**From:** [Gretchen Garland](#)  
**To:** [Rachael Stevie \(CD\)](#)  
**Subject:** RU 22-00002 (East Peak Reasonable Use Variance)  
**Date:** Friday, April 22, 2022 11:56:24 AM

Hi Rachael, please see my comments re: RU 22-00002 (East Peak Reasonable Use Variance) below.

**WETLAND BUFFER
ENHANCEMENT PLAN**

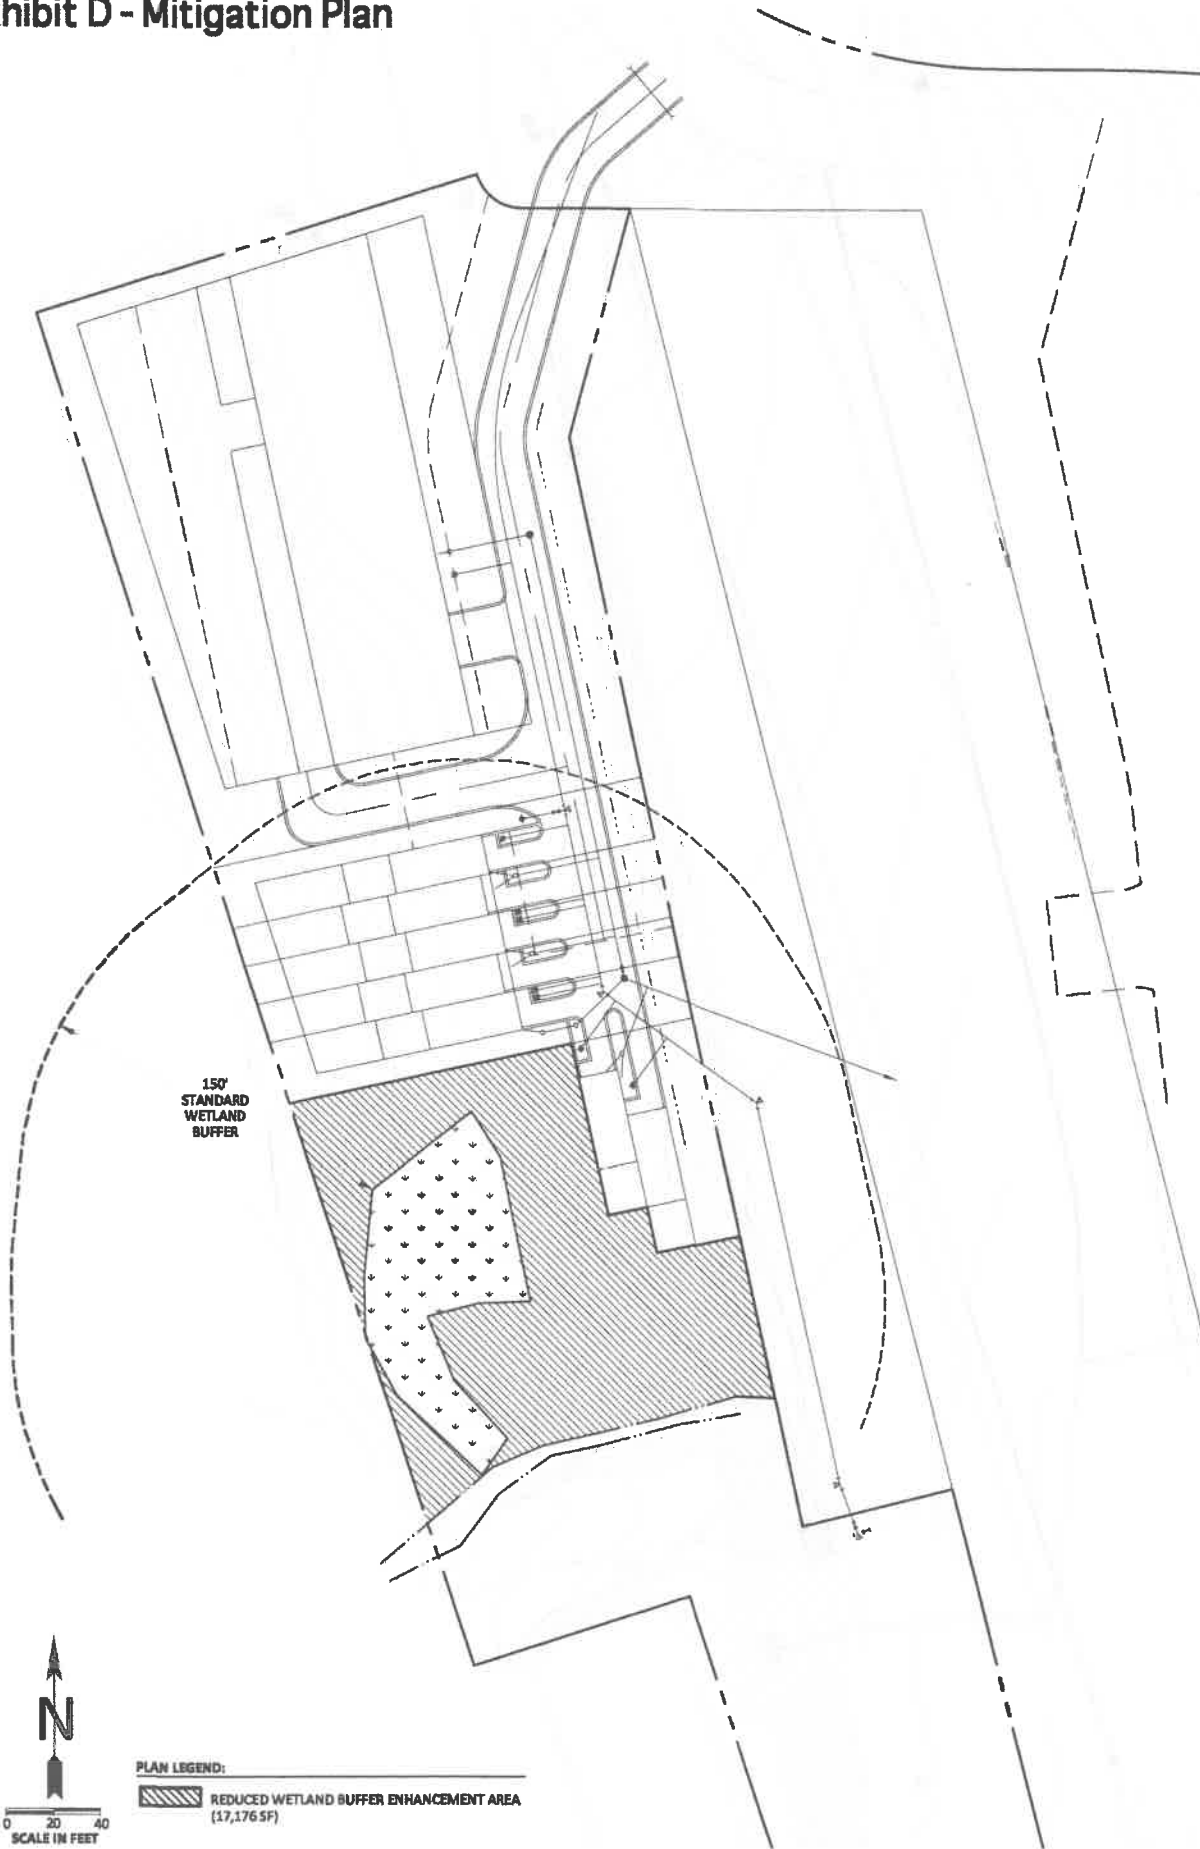
While the proposal describes a plan to enhance a buffer to the east/downhill, it does not address areas uphill and to the south, which could extend the boundaries of the wetland and greatly worsen conditions for the already aging Sundance structure. Further, buffer requirements are put in for this reason—to protect our natural resources and protect building structures from unstable conditions. (Reminder: the Surfside collapse in Florida.)

EXHIBIT A - PROPOSED SITE PLAN

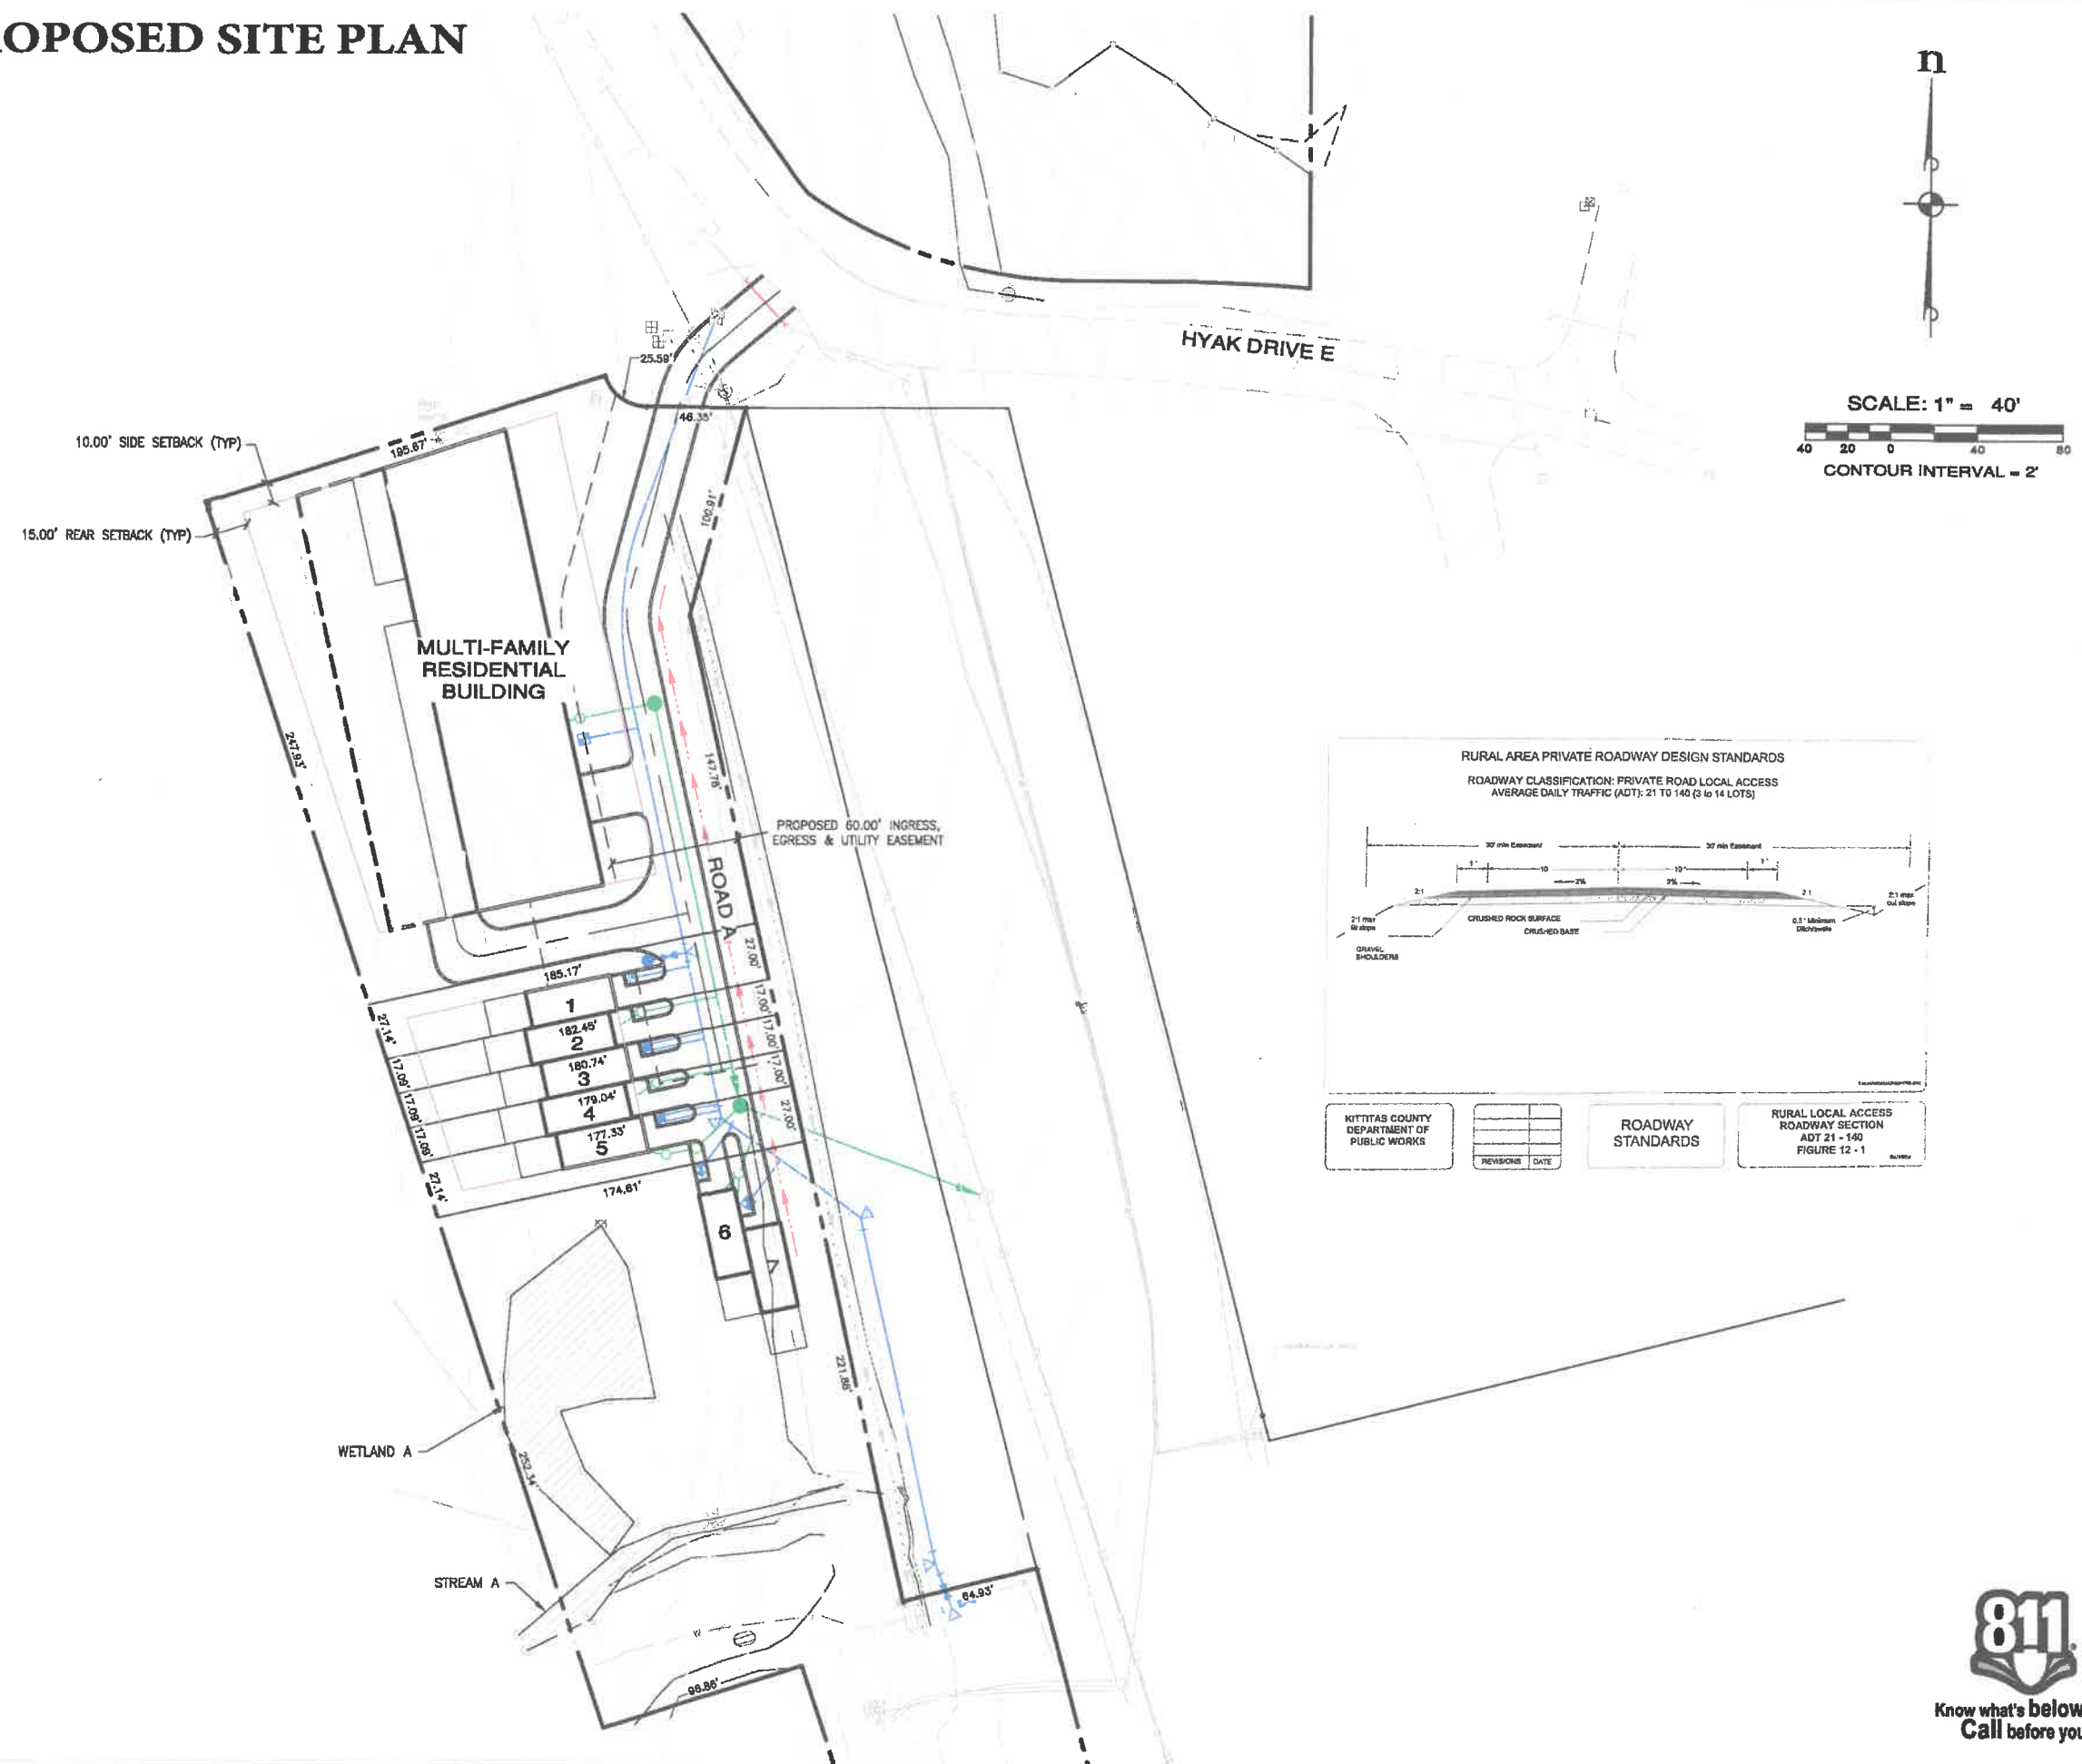
In closing, I recognize that the applicant revised the original proposal to condense the development and move the multi-family structure furthest from the wetlands. As a resident, I am very appreciative of that decision and also trust the CDS will make the best decision for our land and community.
